From: Laura Gibbons <Laura.Gibbons@arun.gov.uk>
Sent: 22 June 2021 14:32
To: Planning.Responses <Planning.Responses@arun.gov.uk>
Cc: Raymond Cole <Raymond.Cole@arun.gov.uk>
Subject: RE: Planning Consultation on: P/79/21/RES

As per P/132/20/RES we wish to raise a holding objection to this application.

Application No: P/79/21/RES

Description of Works: Approval of reserved matters following P/30/19/OUT for 300 No. new homes, internal roads, footpaths & cycleways, car parking & landscaping (resubmission of P/132/20/RES). This application affects the setting of a listed building & falls within Strategic Site H SP2, CIL Zone 1 (Zero Rated).

Project **Hook Lane, Pagham**
Drawing **Site Layout**

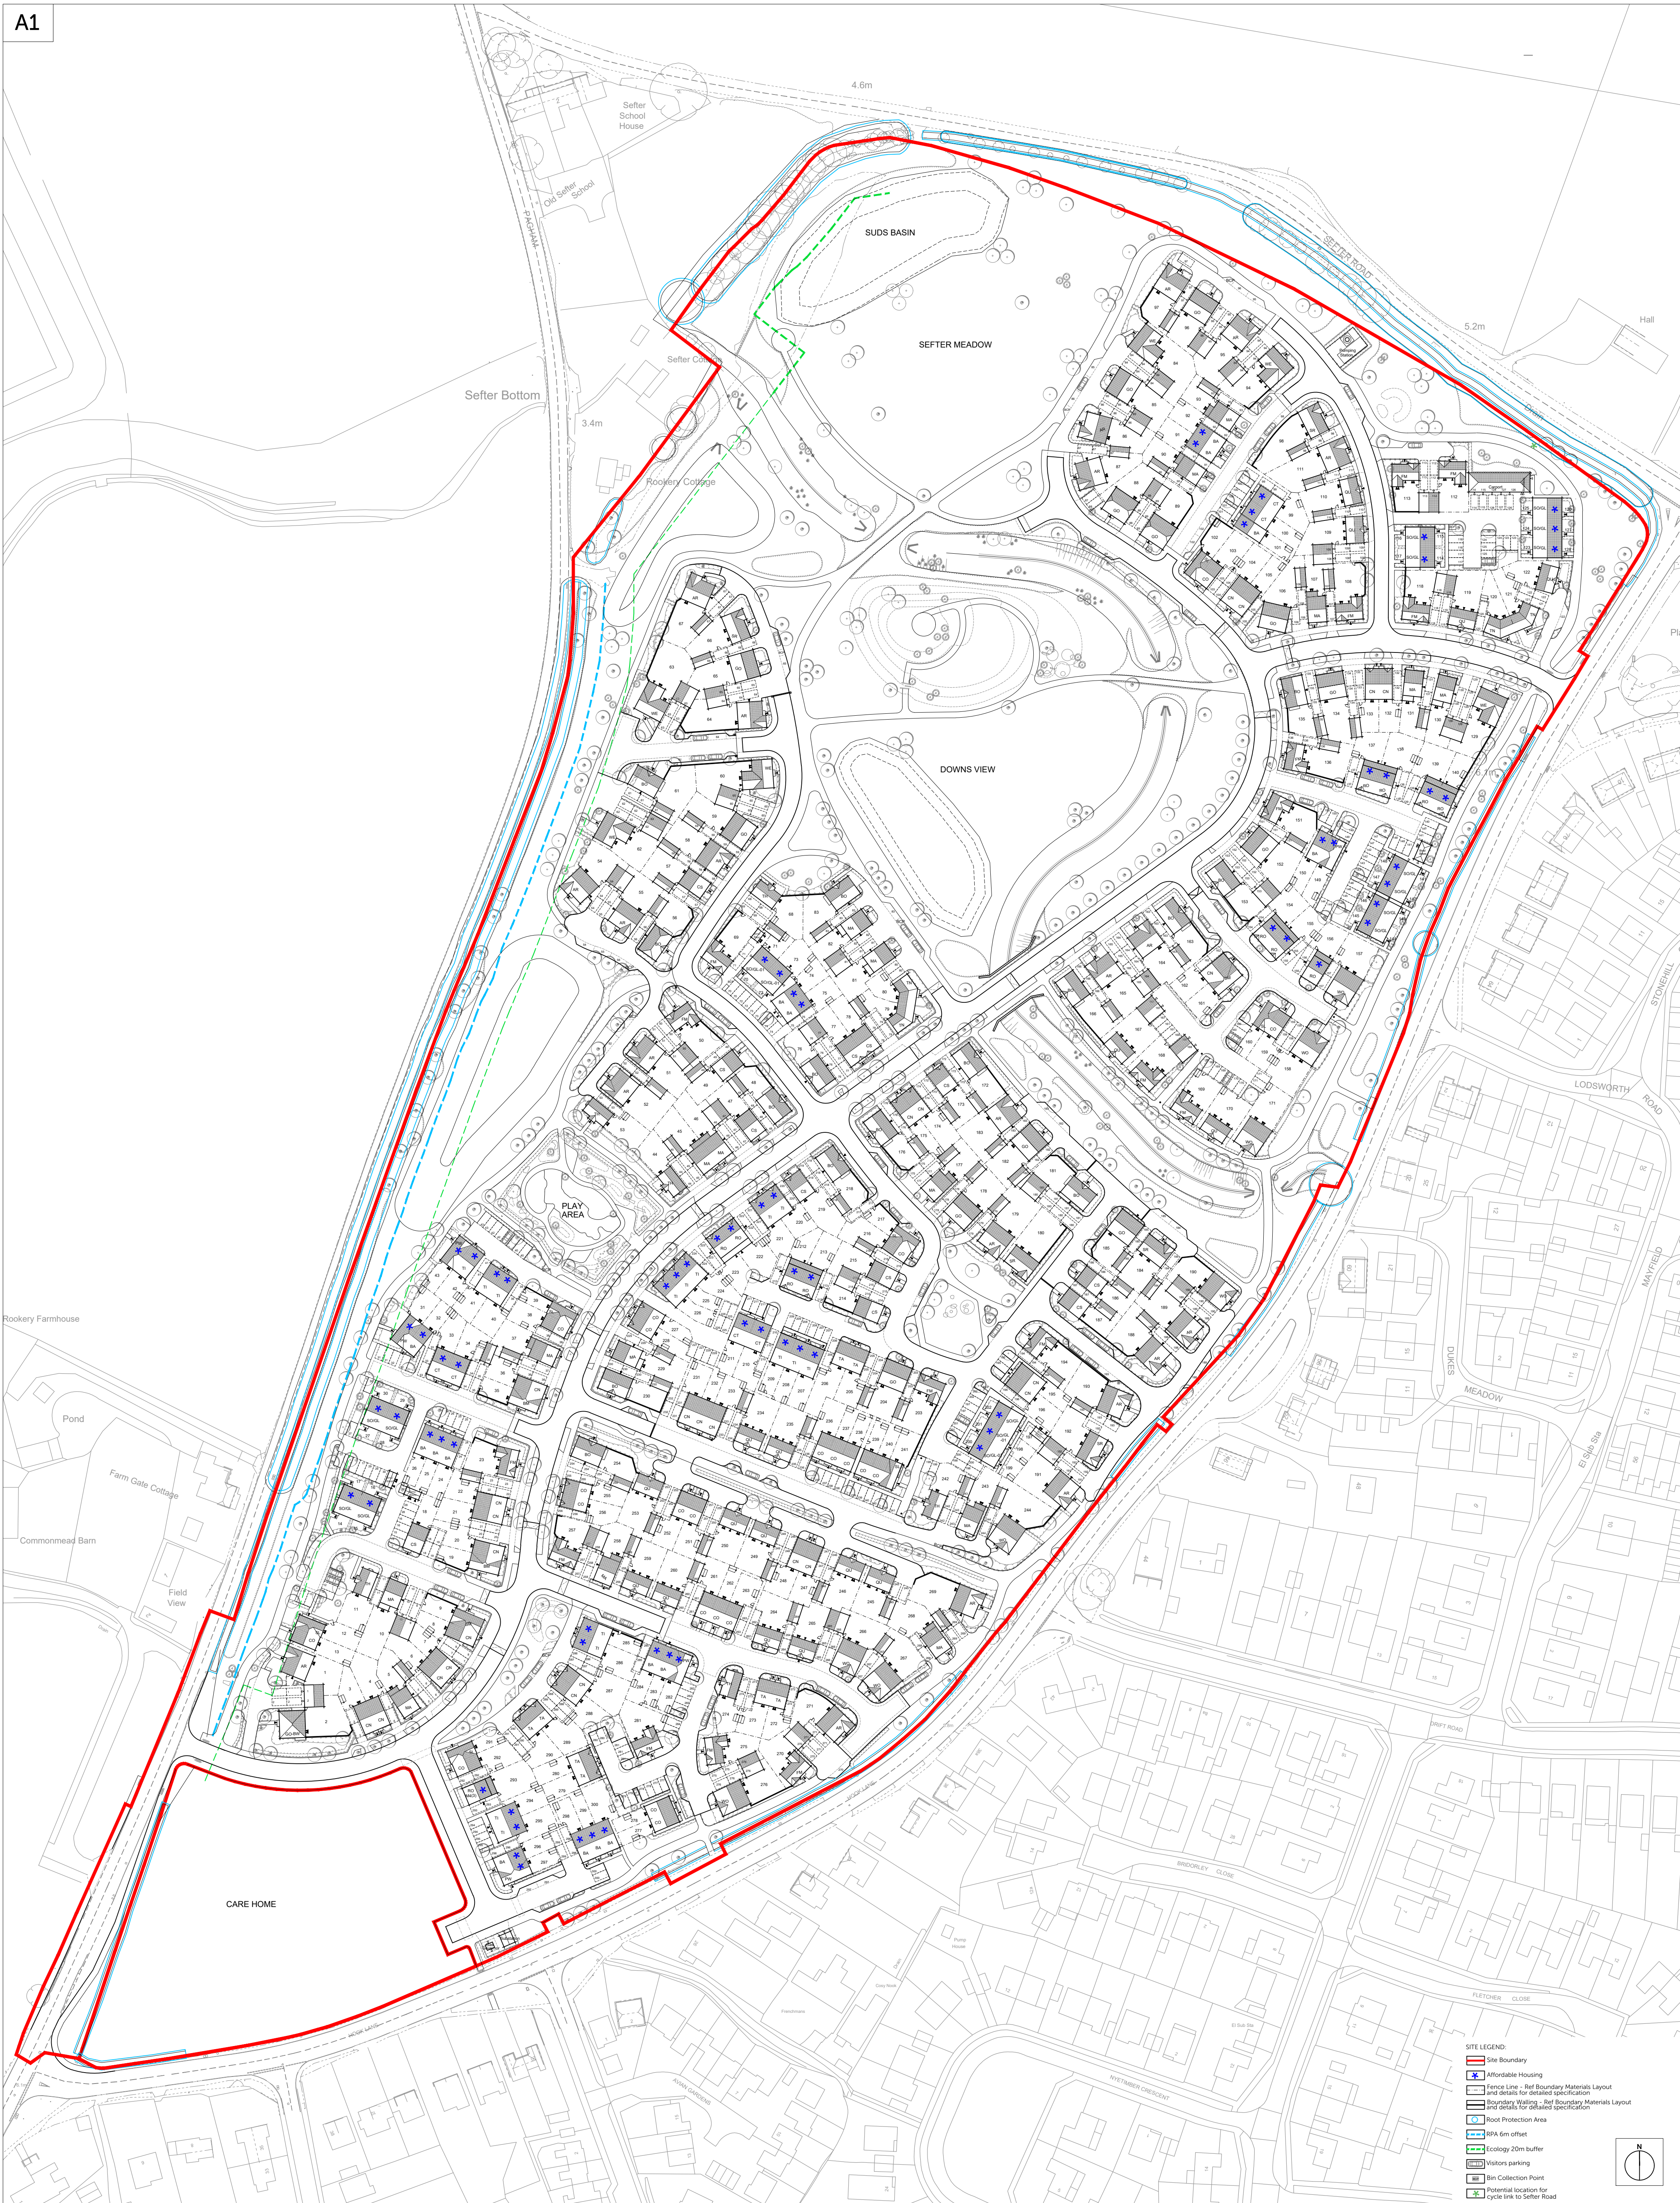
The proposed layout relies heavily upon realigning an ordinary watercourse. We have not been provided with adequate levels information of the upstream and downstream watercourses to be able to determine if the proposals are achievable.

The surface water drainage strategy proposes to discharge all water to one location. Natural catchments must be followed, and a second location for discharge should be provided. As per SuDS Policy 3 of the WSCC LLFA policy for the management of surface water.

To overcome this holding objection the applicant should supply further topographical survey of the upstream and downstream watercourses and the structures within these. The applicant should also supply a revised surface water drainage strategy that follows natural catchments.
